Phone: [REDACTED]  
Email: [REDACTED]  
Your ref: 3/2025/0489  
Our ref: 3\_2025\_0489-LCC  
Date: 26<sup>th</sup> September 2025

**Application 3/2025/0489: Proposed extension to manufacturing facility with associated HV Substation, external plant compound and new/displaced car park.**

**BAE Systems, Samlesbury Aerodrome, Myerscough Smithy Road, Balderstone BB2 7LF**

Project:	7295								
Title:	Proposed Car park Site Plan (Planning) - Reduced								
Project no:	7295	Scale:	As indicated	Drawn by:	JL	Checked by:	KC	Date:	24/09/2025
Drawing no:	OSE-WMA-XX-DR-A-00-020	Status:	D2	Rev:	P02

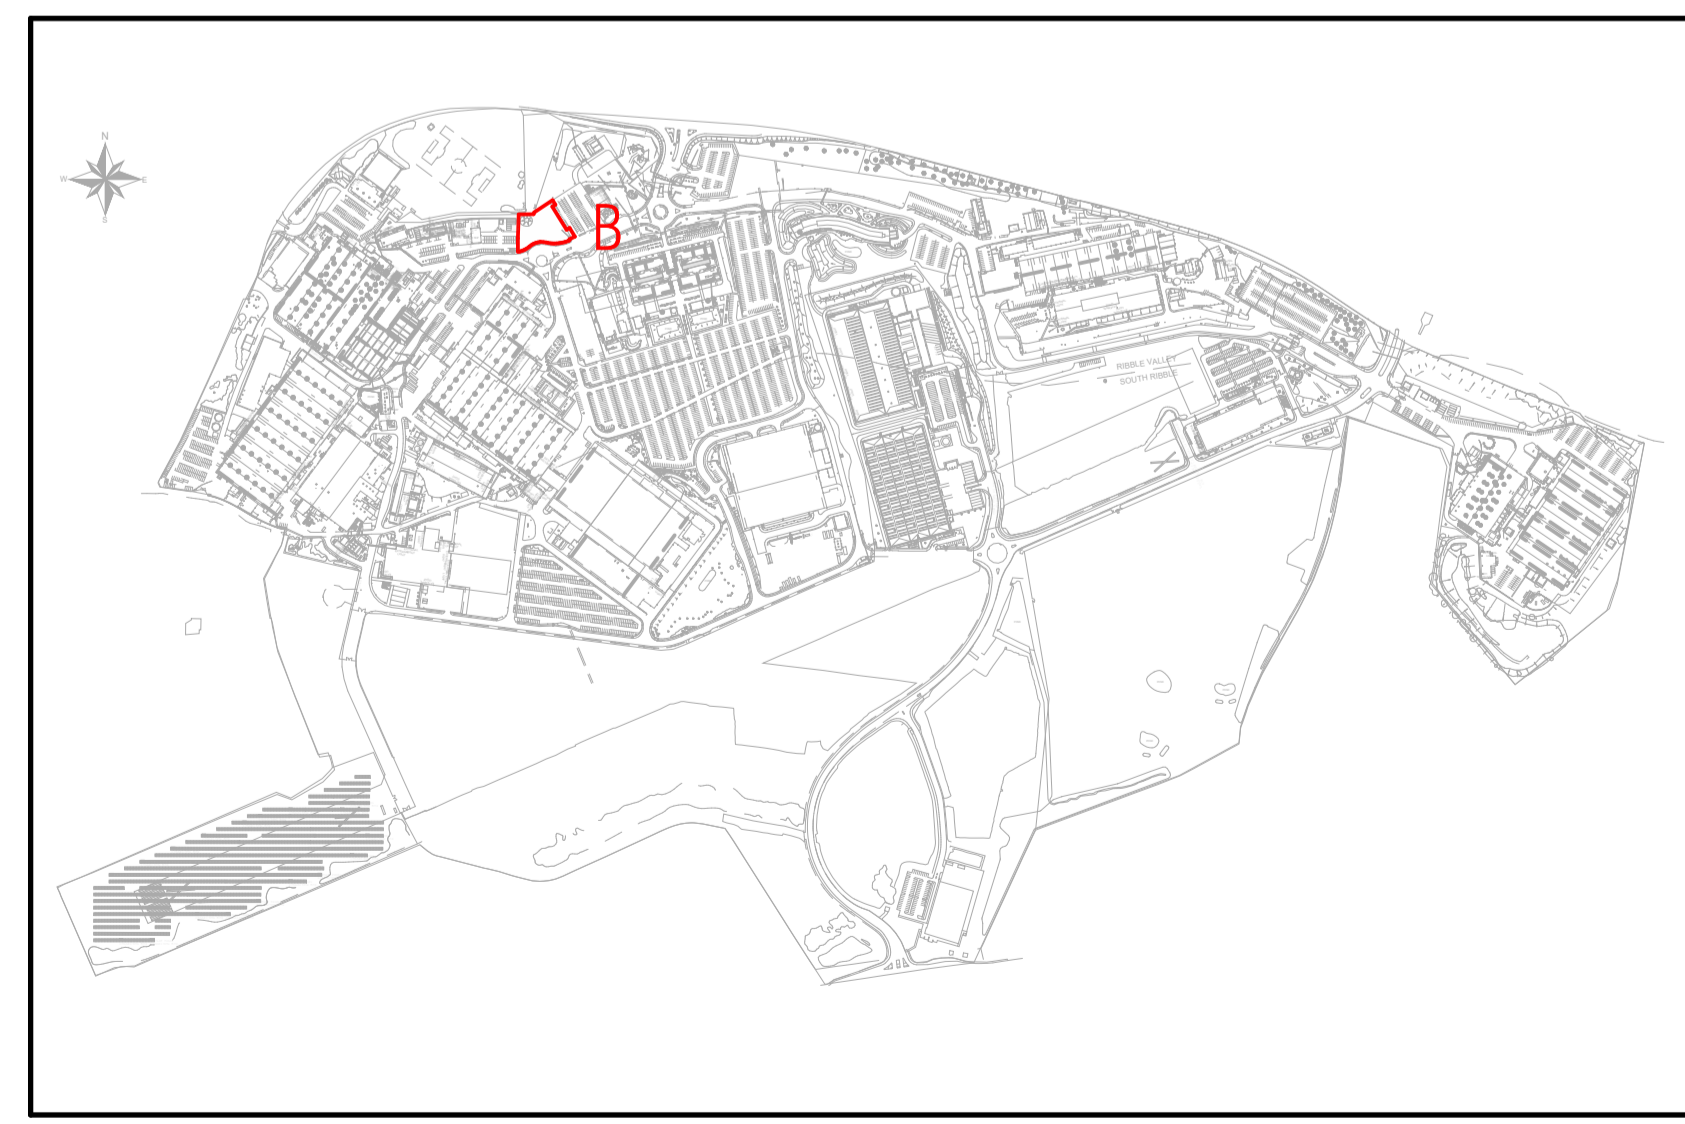
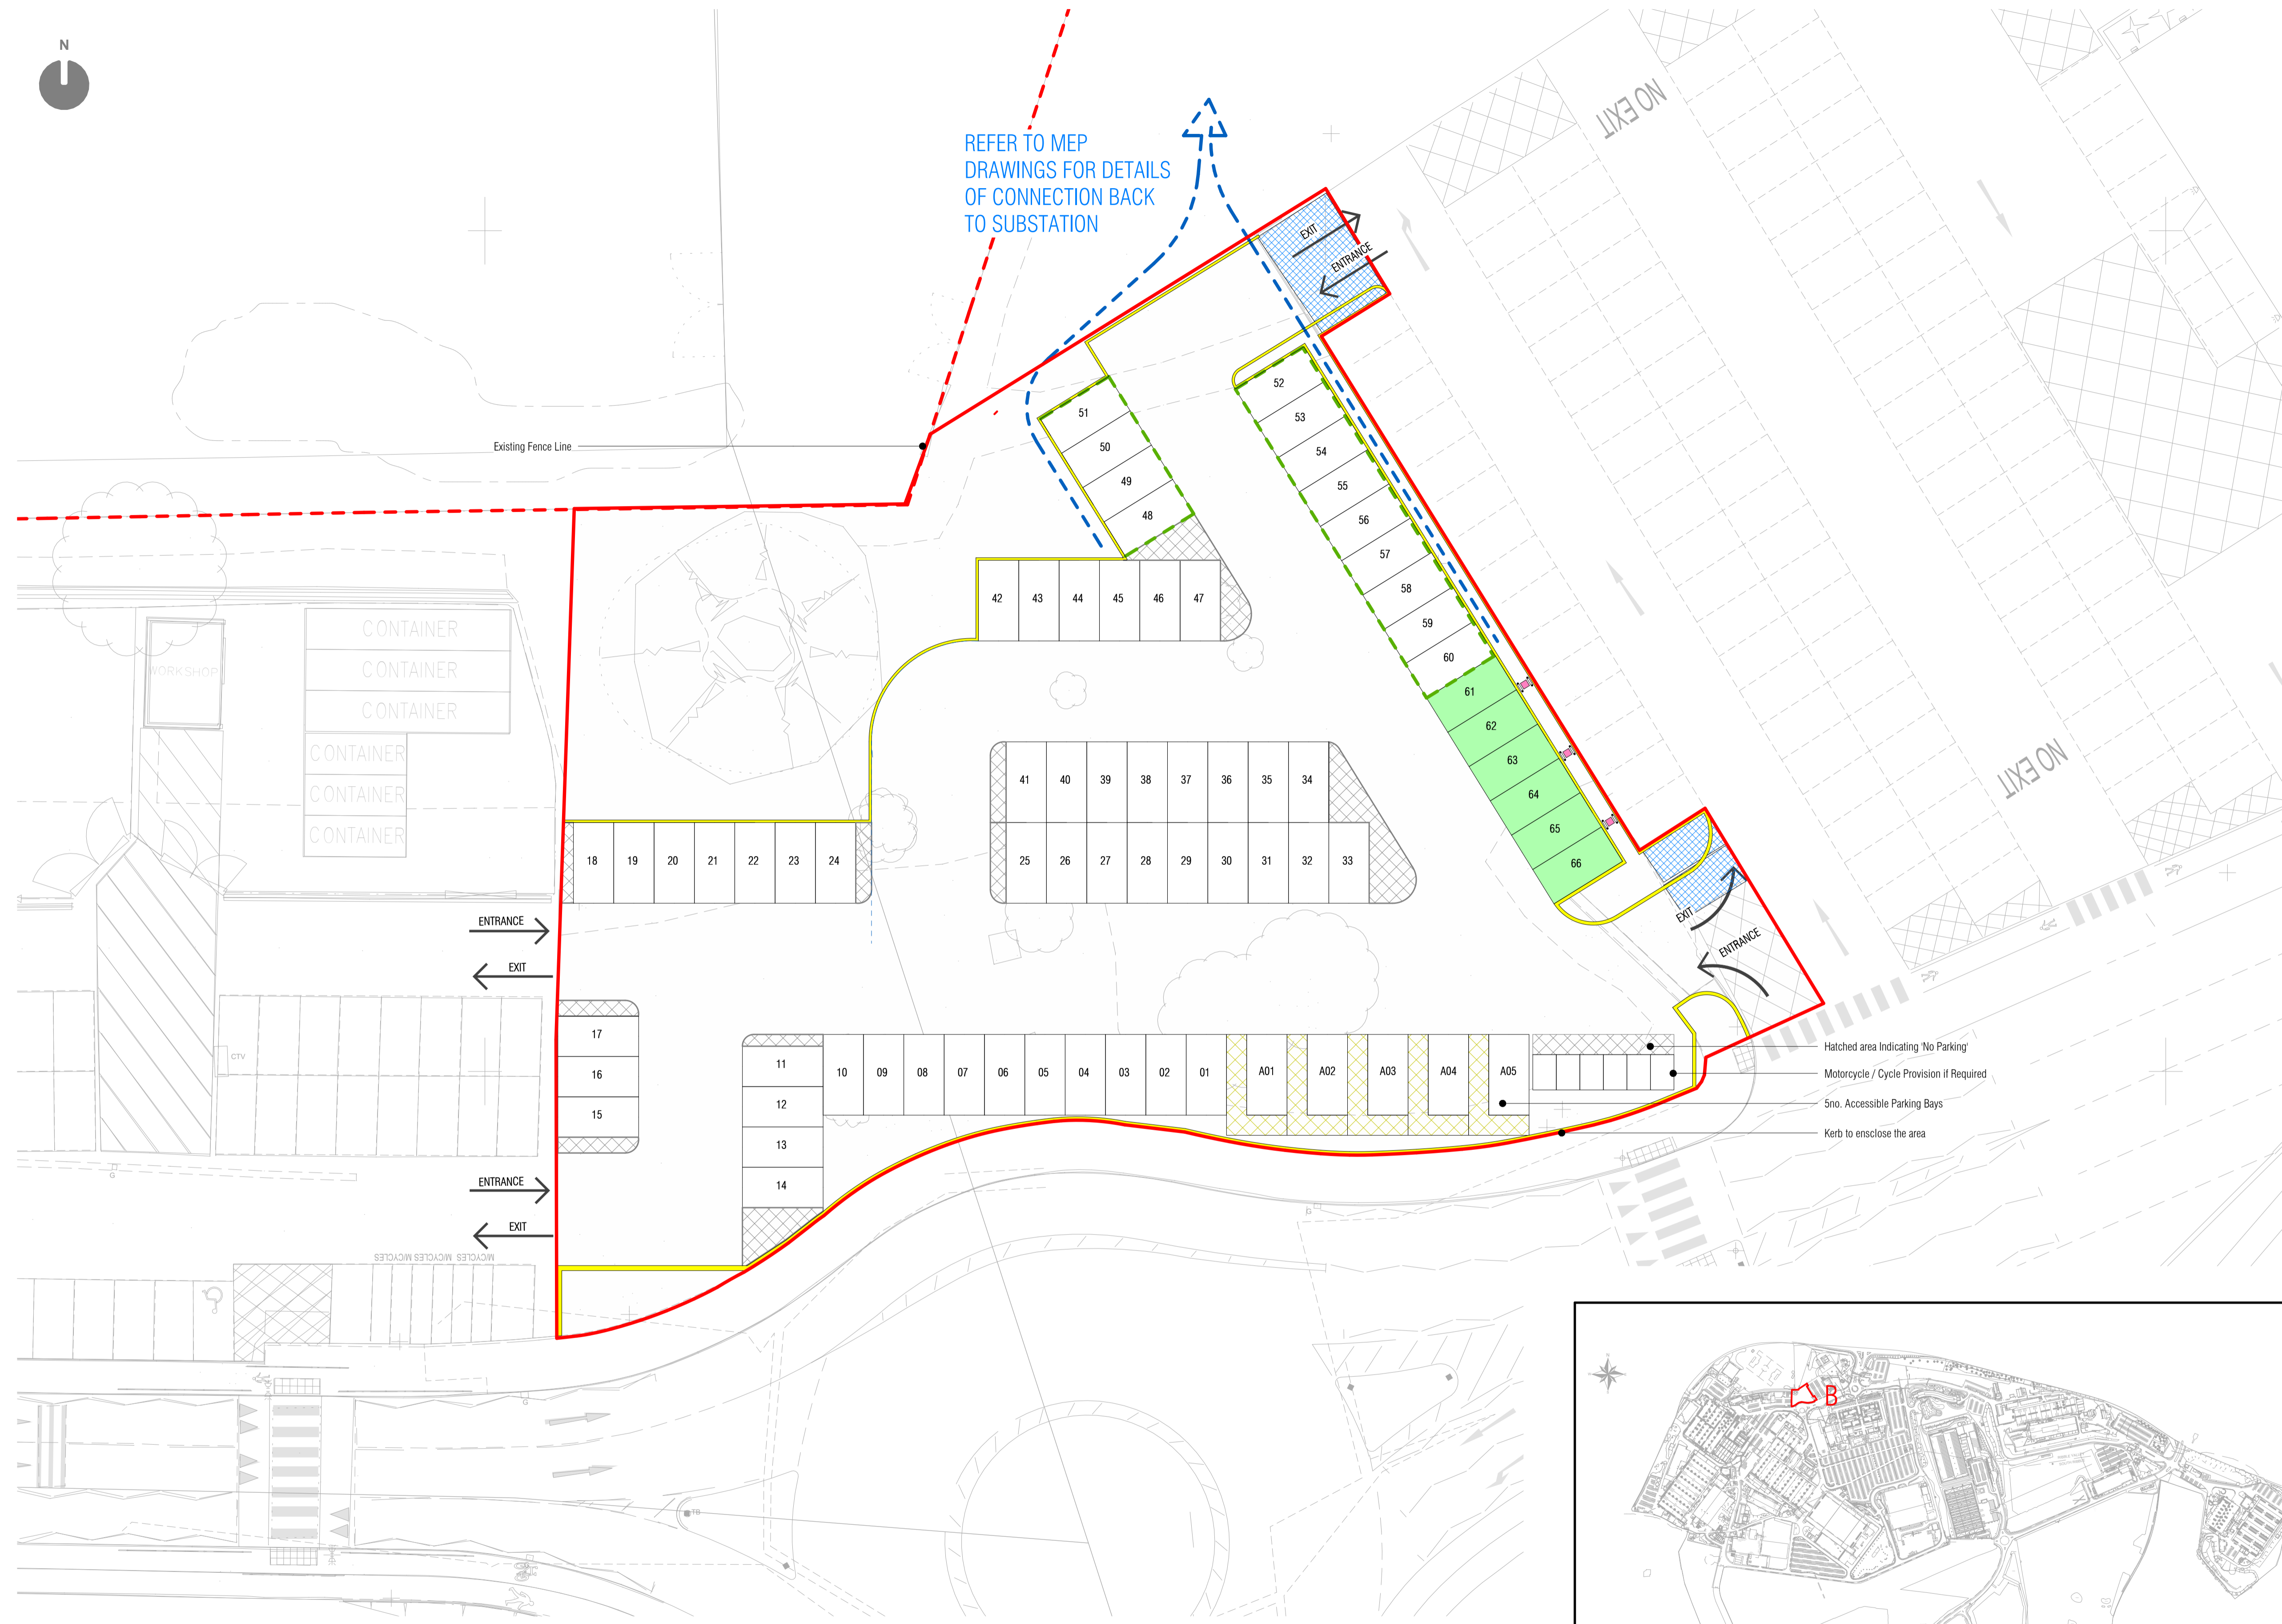
Thank you for your consultation on the above application. We would have no objection to or comment to make on the majority of the elements of the application but note that the works on the proposed car park site (element B of the proposal) have revealed the presence of a concrete former WWII defence structure. Some brief details on this have been supplied in a report from Wilson Mason (document 7295 Rev 01, dated 23<sup>rd</sup> September 2025). As a result, the red line boundary of the development has been redrawn to exclude that structure from the development site (report section 1.4).

We would strongly support the alteration of the proposed development scheme to exclude the structure and would recommend that it is fully uncovered, recorded, and presented to staff and visitors to the airfield. We would stress that great care needs to be taken when cleaning the structure out so that surviving WWII fixtures and fittings, graffiti, wall art, etc. are not unnecessarily damaged or removed. The record of the structure, inside and out, should be to Level 3 as set out in '*Understanding Historic Buildings*' (Historic England 2016) and should be carried out by an appropriately qualified and experienced professional contractor with knowledge of relevant WWII structures and weapons, to the standards set out by the Chartered Institute for Archaeologists. We would also suggest, given the location of the structure adjacent to a car park, that this is an ideal opportunity to erect an information board describing it and the other WWII defence structures present or formerly extant on the airfield.

As the structure has been taken out of the 'development red line' it may not be appropriate to add conditions requiring the above works to be carried out to any consent granted to the current application, but we would hope that the project managers and site owners would seriously consider the recommendations made above. We would be happy to discuss these matters further with them and/or draft a brief for the recording and presentation work if this would be helpful.

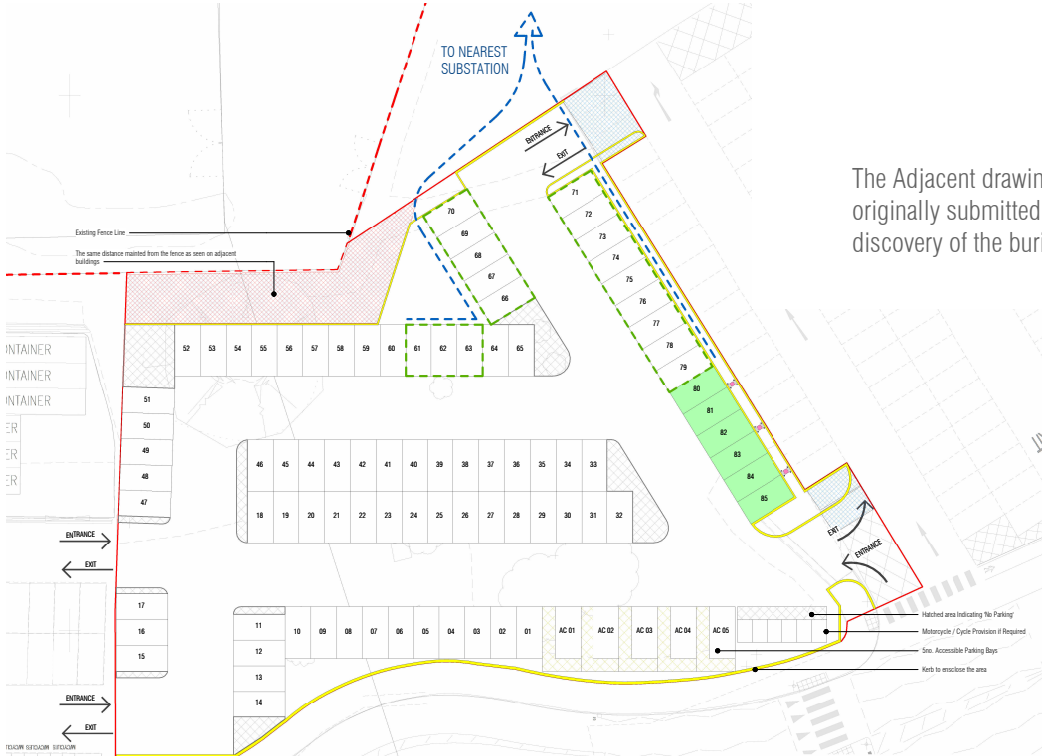
The Wilson Mason report provides some images of the structure, both part-way through the recent uncovering and historic photographs sourced from the client heritage team. The report also suggests that this structure is an adapted "... *Type 24 pillbox* ..." (section 1.3). In fact the structure, whilst it could be categorised as a pillbox, bears little correspondence with a Type 24, which should be quickly obvious when comparing the photographs supplied with the known Type 24 pillbox that stands on the edge of the sports pitches some 175 to the northwest at SD 62239 31648. The structure is noted in the Council for British Archaeology's "Defence of Britain" database ([https://archaeologydataservice.ac.uk/archives/view/dob/ai\\_full\\_r.cfm?refno=6838](https://archaeologydataservice.ac.uk/archives/view/dob/ai_full_r.cfm?refno=6838)), although it is only given a six-figure NGR. There it is described as a 'variant' type, i.e. not one of the standard pillbox types, and is a:

Some further research, particularly on the Pillbox Study Group's website, would also suggest that many airfield defence structures were designed to suit their particular needs, rather than conforming to one of the 'standard' types. Examination of the photographs in the report and details in the LCC aerial photographic survey of 1963 would suggest that the description could be revised to state that the structure appears

to be an octagonal concrete core (a Type 24 is an irregular hexagon) with extended wings on alternate faces. On its northwest and southeast faces the wings appear narrower, that to the northwest having a low personnel doorway facing southwest into the airfield. The southeast side is also extended out as a broader wing, but in this case to form a full-width firing or observation slit protected by a concrete apron and overhanging roof. Whilst LCC 1963 aerial photography (Run 10, frames 9653 and 9654) would suggest a second such feature on the opposing northwest face, this is not illustrated in the report. The intermediate south and east faces of the octagon between the wings have small rectangular embrasures, possibly stepped as suggested above or with frames, but their presence on the north and east faces is as yet unconfirmed.

The size and shape of this structure, and its location further back from the perimeter within the airfield proper (the 1940s/1963 aerial photography shows it to have been adjacent to a perimeter road/taxiway and aircraft parking) might suggest more of a 'command and control' role within the wider airfield defences, of which we have little information but which may be set out within the BAE archives. It is probable that further field investigation will 'flesh out' the above description and allow more considered conclusions to be reached regarding the role of this structure and what weapons it was intended to house.
